Engineers comments in respect to surface water drainage and land drainage;

APPLICATION NO: P/24/20/RES

Site Address: Land North of Sefter Road & 80 Rose Green Road Pagham

Description of Works: Approval of Reserved Matters pursuant to condition 1 (Reserved Matters details), condition 6 (Design Code Masterplan) and condition 7 (landscaping and layout details) following the approval of Outline planning permission P/134/16/OUT for the erection of 280 dwellings, (including affordable homes), replacement scout hut & Ambulance Community Response Post Facility; provision of a primary vehicular access from Sefter Road; demolition of No. 80 Rose Green Road & creation of a pedestrian & emergency only access; provision of Public Open Spaces including associated children's play areas, landscaping, drainage & earthworks. This application also lies within the parish of Aldwick. This site falls within the Pagham North SD2, CIL Zone 1 (Zero Rated).

FIGURE 7.3: SUDS POND

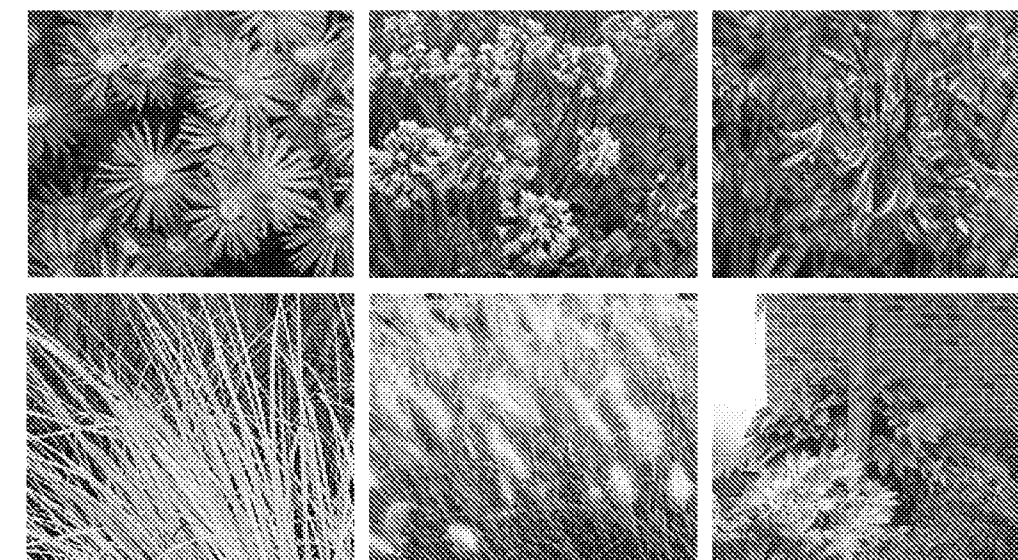
3. Some of the suds open features will require some tweaking to ensure that a 3m access strip is achieved around their entire perimeters to allow future maintenance access.

6. Please note that no open suds features are to be counted towards the public open space provision.
7. The proposed suds pond in the NW corner of the site and the associated ditch diversion (subject to Land Drainage Consent), appear to be located within an area of 'existing vegetation' to be retained. Some clarity is required here, since the construction of the pond and ditch will have a significant affect on any vegetation in the immediate area.
